Our ref:
MS/6364/OCCLLFAR/

10 March 2022

Planning Ref: DC/21/2571/VOC

Location: Jacobs Douwe Edberts, Ruscote Avenue, Banbury,

Title:
Drainage Layout

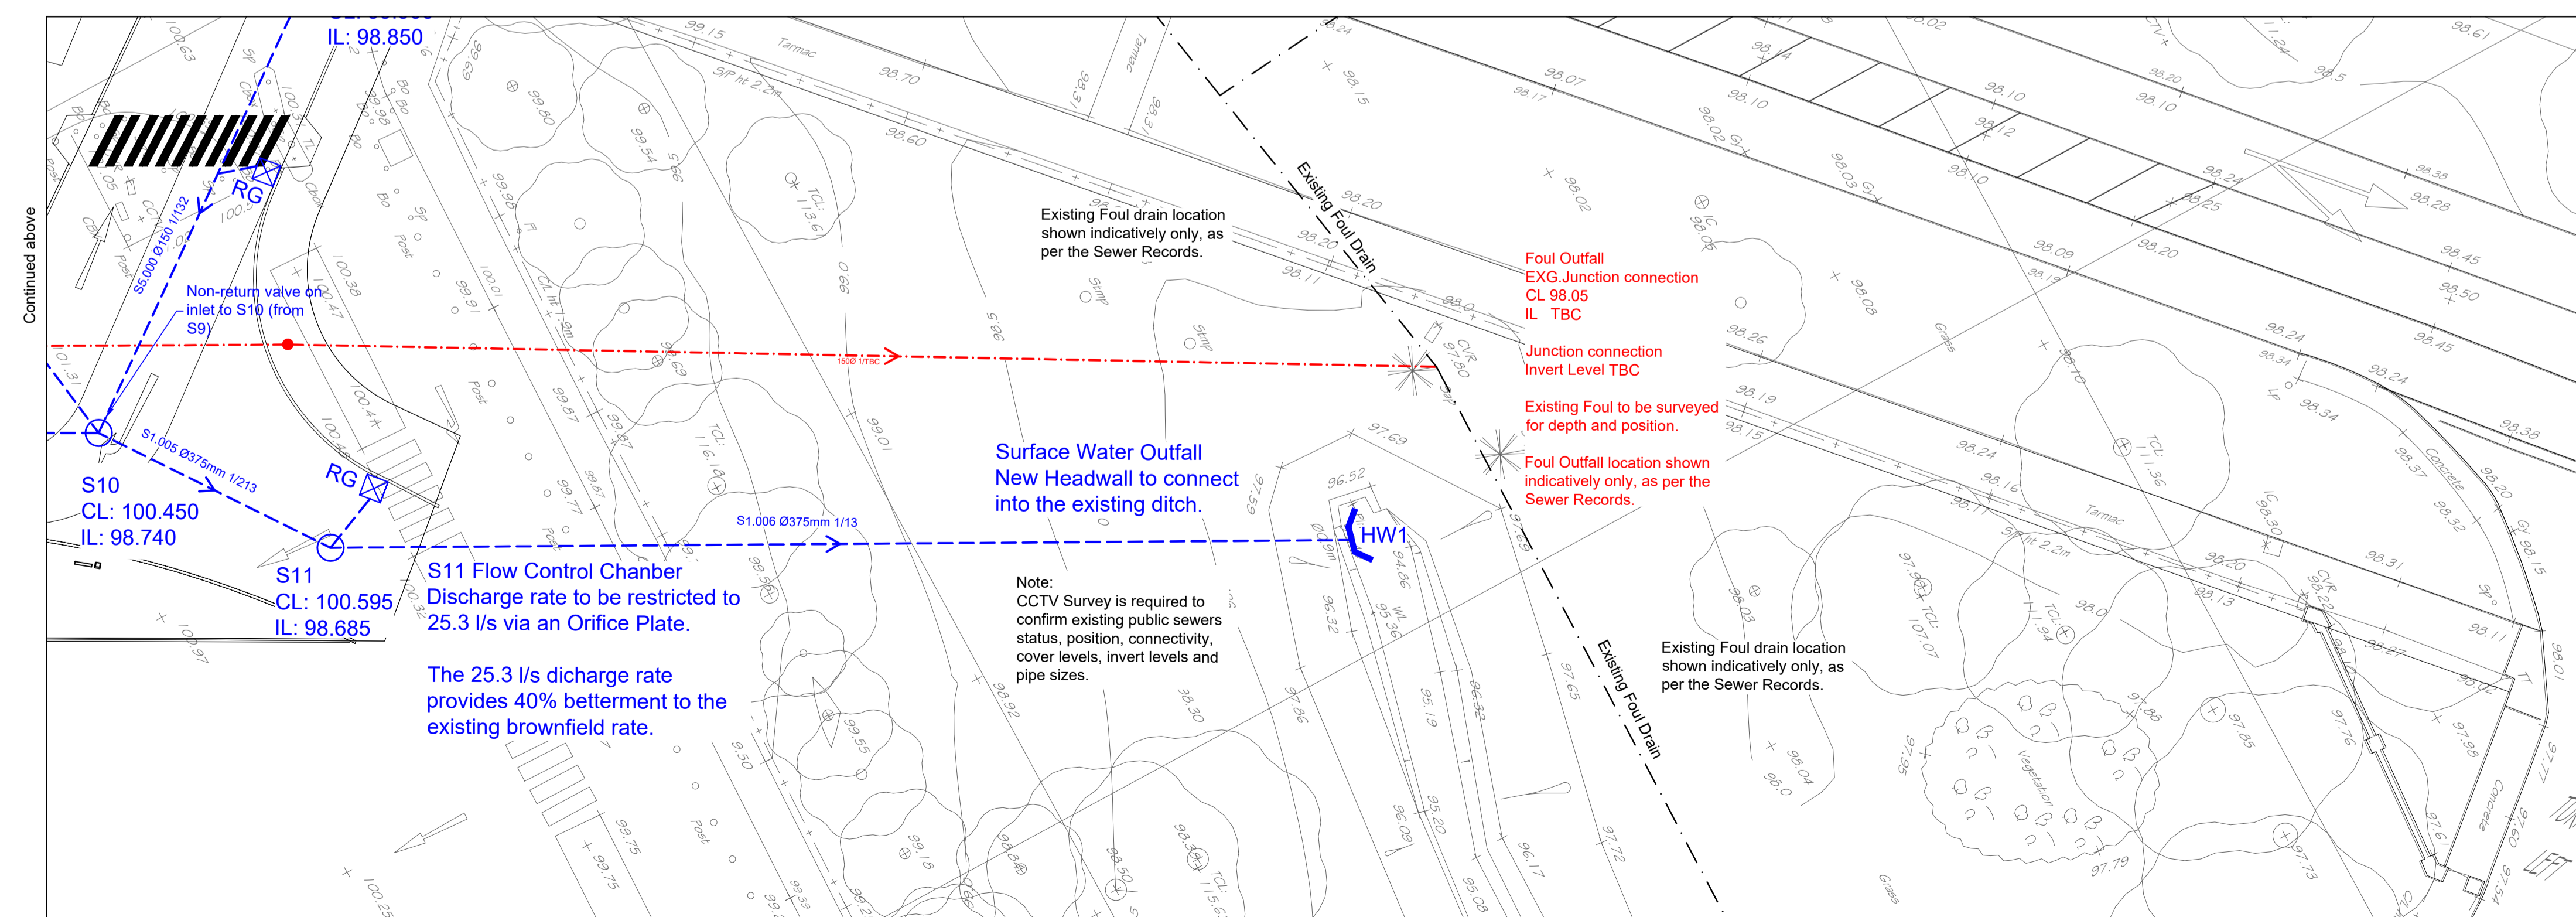
Provide storage volumes of the SuDS features on plan which should reflect the calculations. – The invert level of the permeable paving is above the ground level of the lowest drainage feature, therefore all storage capacity within the system is obtained within oversized pipes where possible. Permeable paving sub-base will be tanked type C system with a depth designed to accommodate onsite obtained CBR values for structural strength.
